The Burnet Heritage Trust's (BHT) response to ExQ1 (issued Friday 9th May 2025), including.

- Comments relevant to Question 1.6.1
- An answer to Question 1.6.2
- Comments and new information relevant to Question 1.6.8
- Comments and new information relevant to Question 1.6.9.
- Comments relevant to Question 1.6.18
- Comments relevant to Question 1.6.20 and 1.6.21

FIGURE NUMBER
 Figure 8-8-1

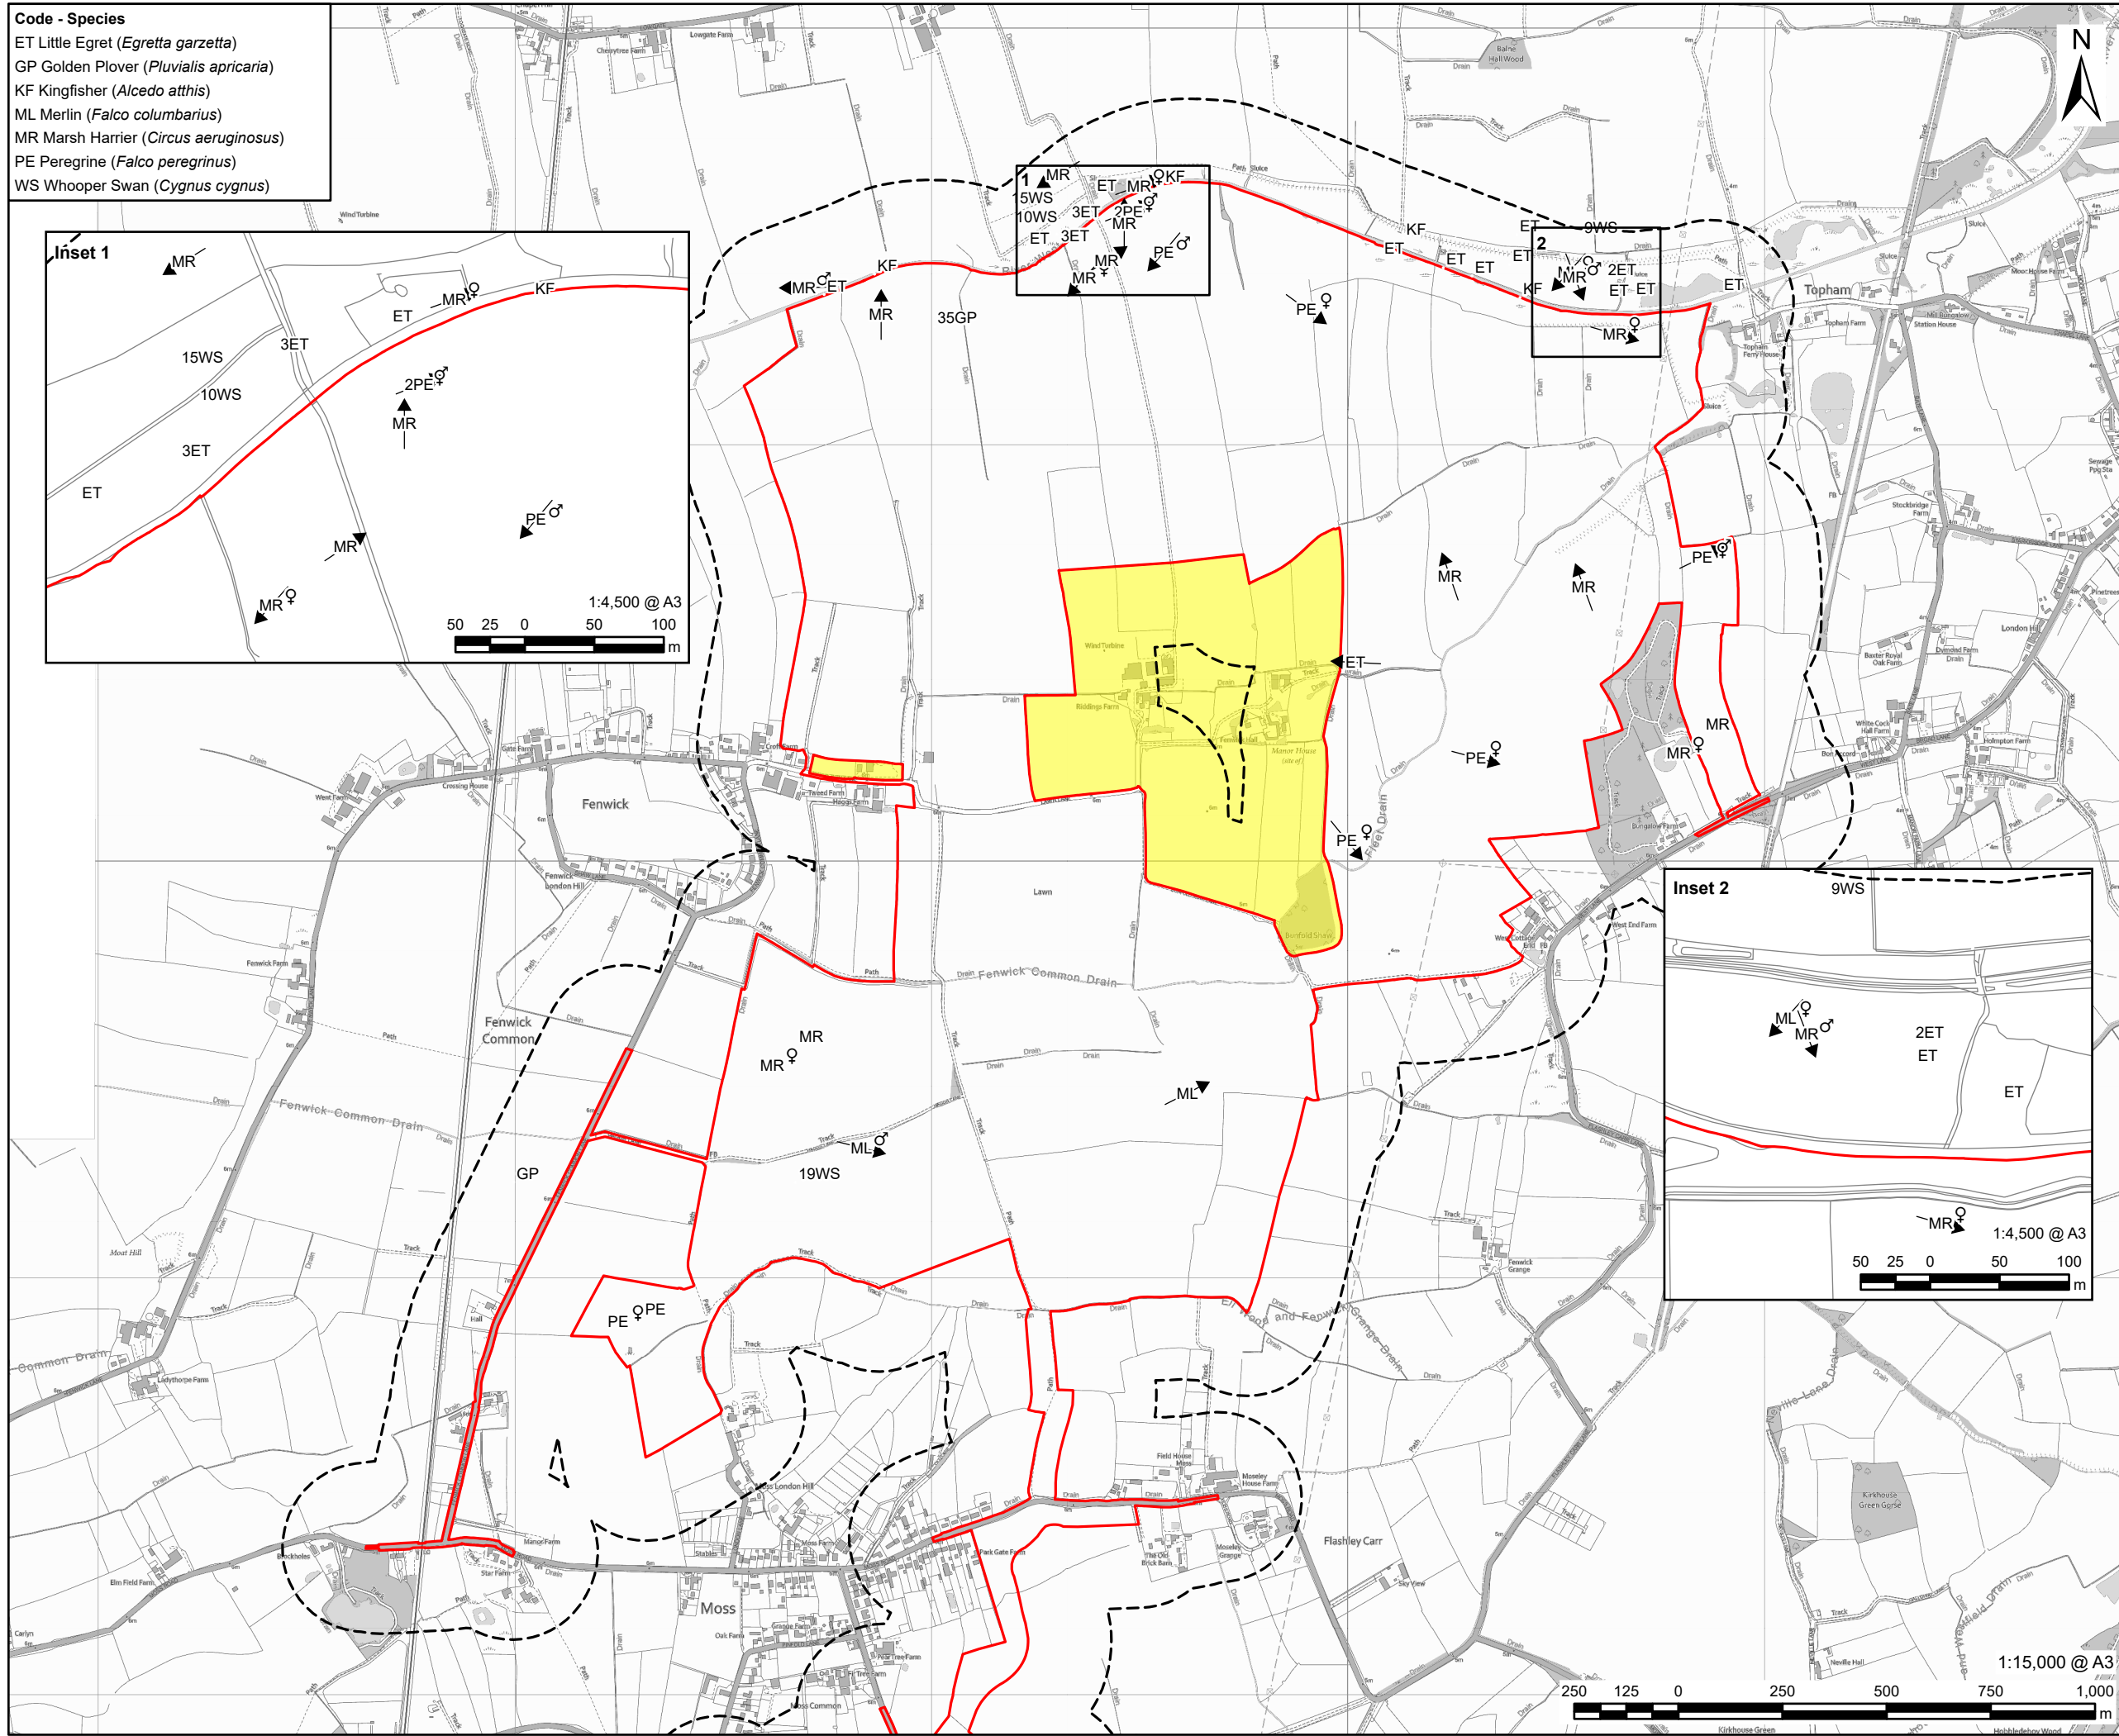
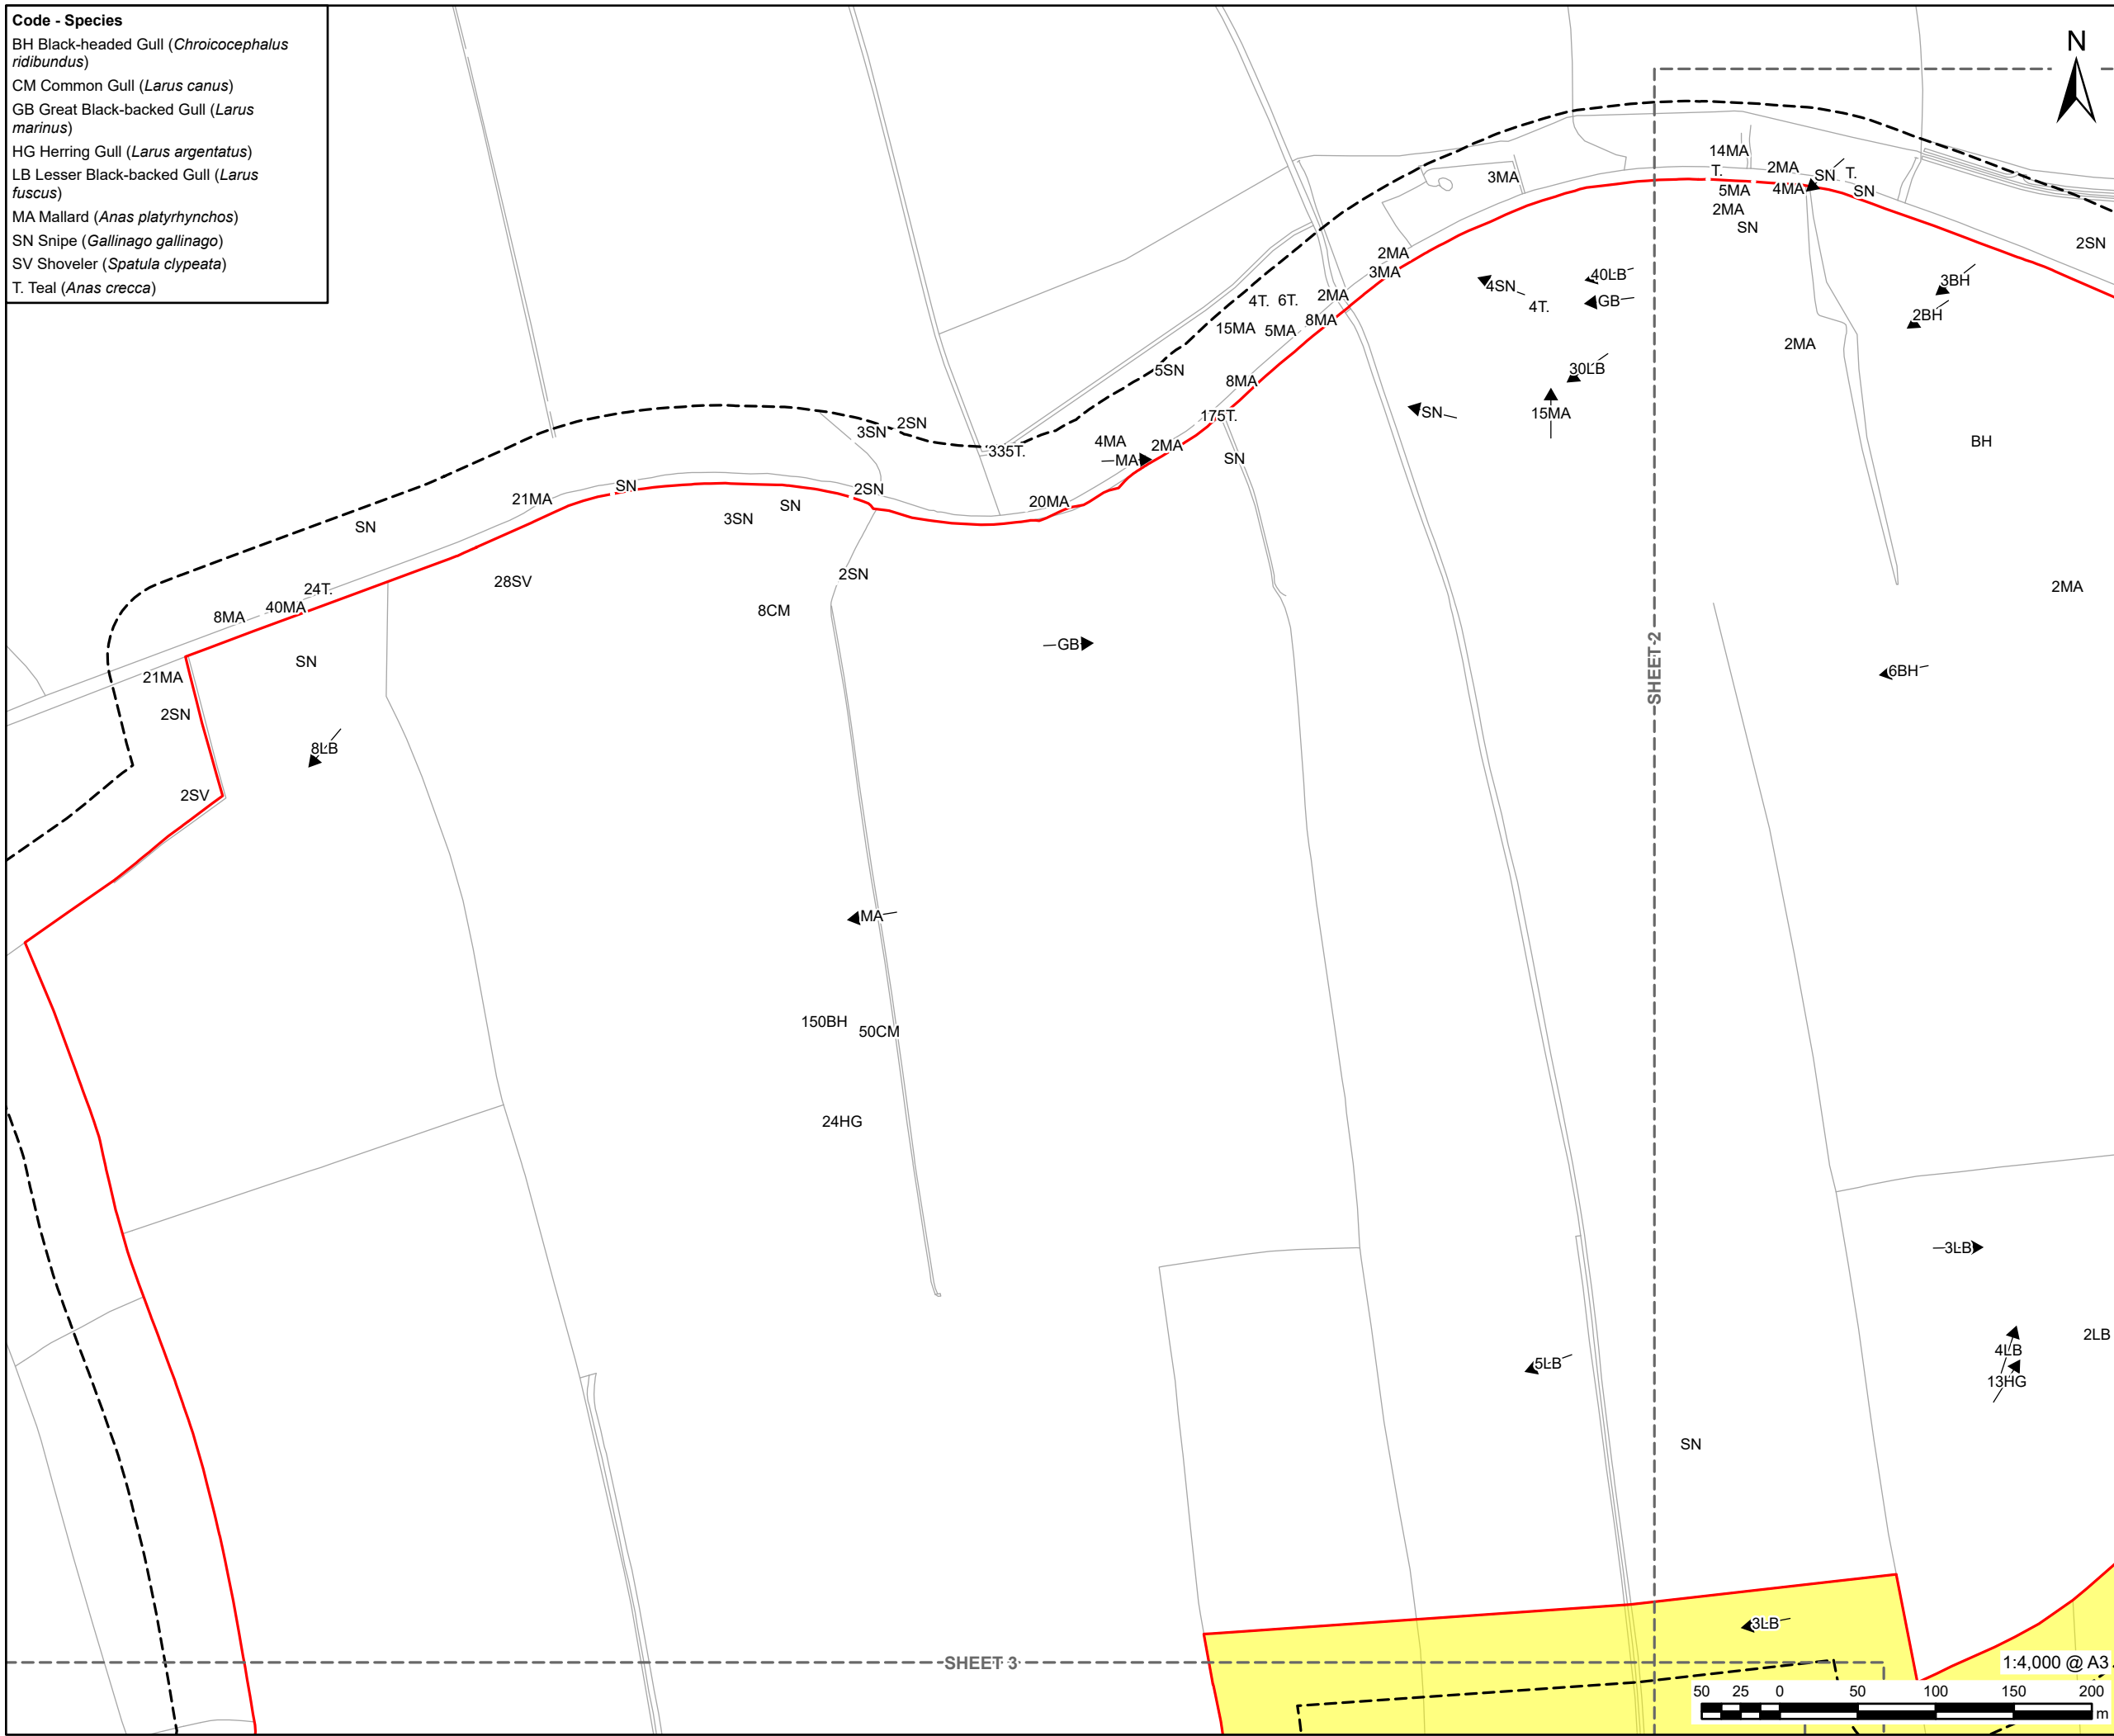
Ref:	Question to:	Question:
1.6.8	Applicant	<p>The Burnet Heritage Trust have commented [RR-011] there are a number of species that have not been surveyed or included within ES Appendices 8-7 [APP-152 and APP-153] and 8-8 [APP-154] as follows:</p> <ul style="list-style-type: none"> • Table 4 of ES Appendix 8-7 states that Marsh Harrier is not within the order limits. As Marsh Harrier is identified within Annex 1 Birds of Conservation Concern (BoCC) Amber list, please confirm survey distance for this species given the methodology set out within Section 3 of ES Appendix 8-7 and given the ecological protection afforded this species. • Grasshopper Warbler have not been surveyed. Given this species is a Species of Principal Importance (SPI) and is listed on the BoCC Red list, please confirm the extent of the surveying distance for this species given the methodology set out within Section 3 of ES Appendix 8-7. • Marsh Warbler have not been surveyed. Please confirm if this species was surveyed and if not, why not. • Garganey have not been surveyed. Please confirm if this was surveyed and if not, why not.

The Burnet Heritage Trust; Comments relevant to Ref 1.6.8		<p>The Burnet Heritage Trust welcomes the Examining Authority's queries regarding the thoroughness of bird surveys. The Trust has provided information to direct interested parties to the sources of the relevant data (REP1-054).</p>
The Burnet Heritage Trust; New information relevant to Ref 1.6.8 and the proposed issue-specific hearing (ecology and mitigation).		<p>The Trust would again query the omission of curlew records from the applicant's surveys and the species listed above (1.6.8). The Trust has provided records on numerous occasions, and a recent EIR data request confirmed that Natural England also accepts the presence of curlew in the area.</p> <p>See attached documents: EIR202504725_24-01-24_email_Redacted EIR202504725_EIA letter_Redacted</p> <p>In correspondence with the landowner, NE asked the landowner to confirm in which of the land parcels under investigation, curlews had attempted to breed. In their letter to the landowner regarding the outcome of their investigation, they state "...we found evidence of curlew breeding in the vicinity..."</p> <p>As the Government's own conservation agency is satisfied that there is evidence of Curlew in the area, the Trust would ask that the presence of Curlew be accepted and for the Impact Assessment to be reviewed to provide the necessary mitigation.</p>
